Recommendation Report for Planning Permission for Works or Extension to a Dwelling

REF NO: FP/126/25/HH

LOCATION: 2 Stanhorn Grove
Felpham
PO22 8FP

PROPOSAL: Conversion of detached garage to form annexe.

NORTH

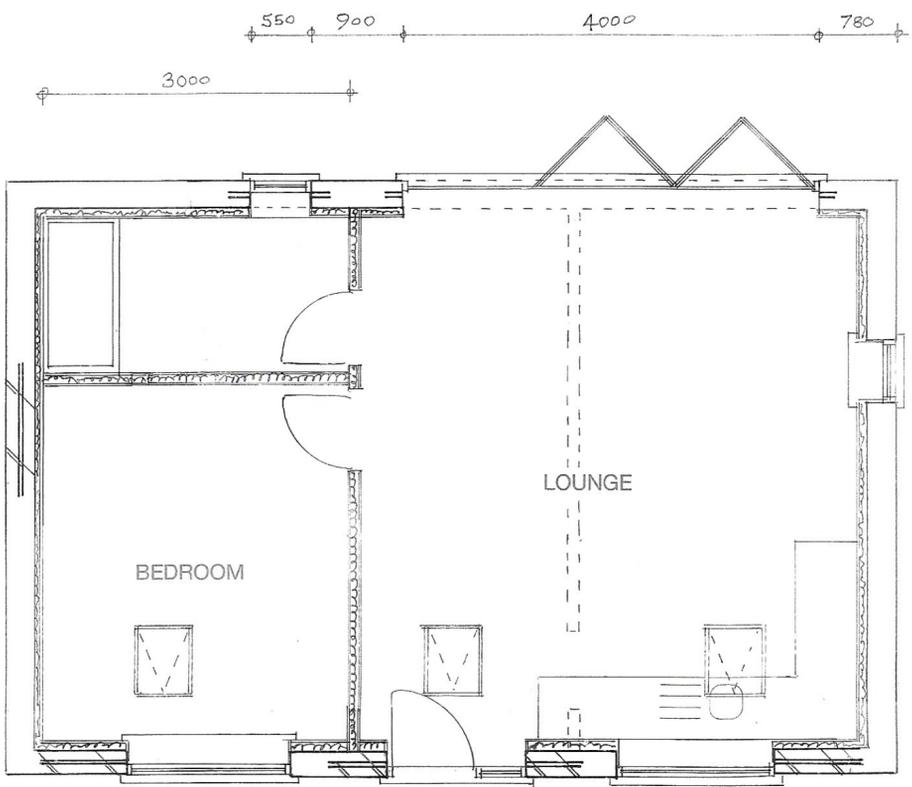
The detached garage is positioned to the east (front) of the host dwelling and is visible from the street scene. The proposal seeks to convert the garage into habitable accommodation, including alterations to fenestration. Specifically, the existing side (west) door would be removed; the rear (north) elevation would feature new sliding doors and a window; and the front (south) elevation would include the removal of the garage doors and the installation of an entrance door flanked by two windows. The existing rooflights and side (east) window would remain unchanged.

The proposed garage conversion would include the replacement of the existing garage door with a standard entrance door and it would introduce additional windows to the south elevation. Further fenestration changes include patio doors and a window to the north elevation, and the removal of a door to the west elevation.

The new rear (north) fenestration would overlook the existing garden amenity space which currently serves the host dwelling. This arrangement would not result in overlooking. The additional fenestration to the front (south) would not directly face neighbouring dwellings and are partially screened by mature vegetation.

PLAN

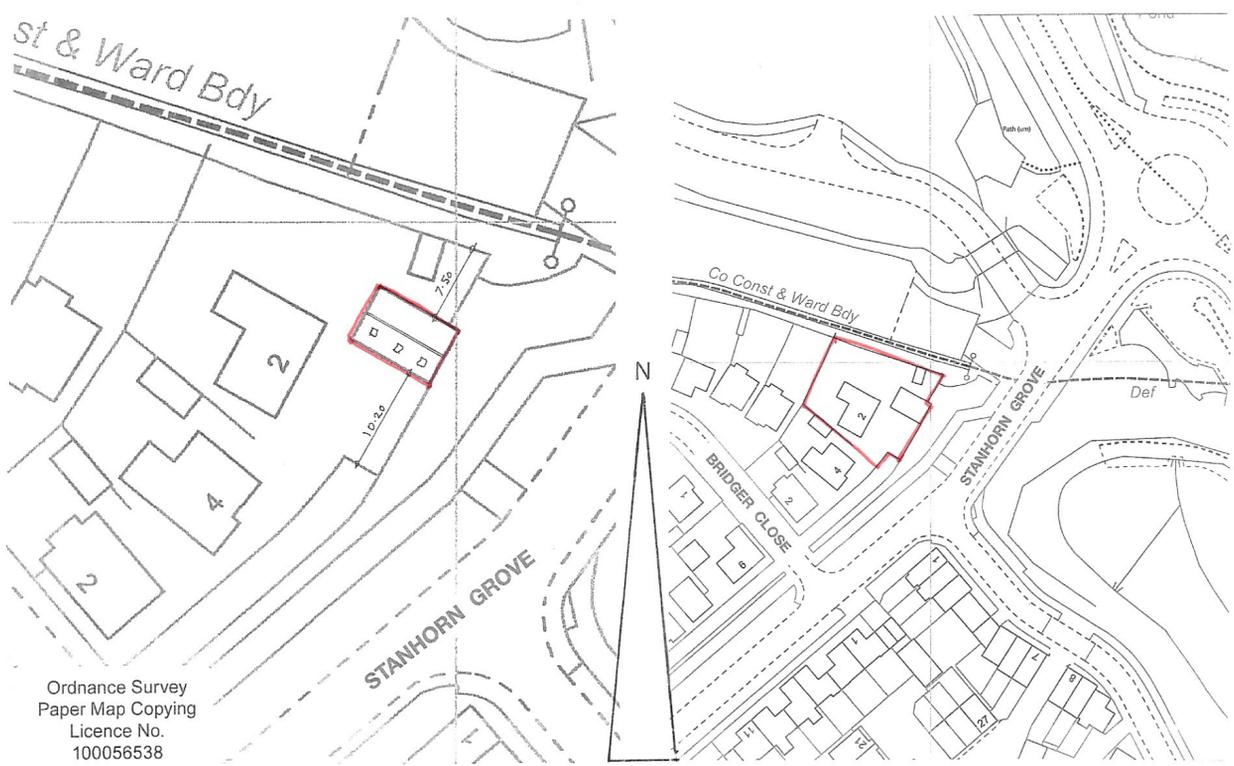
The Arun Design Guide advises that internal spaces should meet the Nationally Described Space Standards (NDSS) to ensure suitability for current and future occupants. An objection was received citing concerns over insufficient internal space. NDSS sets a minimum Gross Internal Area of 39 square metres for a one-bedroom dwelling with a bathroom. The proposed annexe would provide approximately 40 square metres, thereby complying with NDSS, the Arun Design Guide, and Local Plan Policy D DM2.
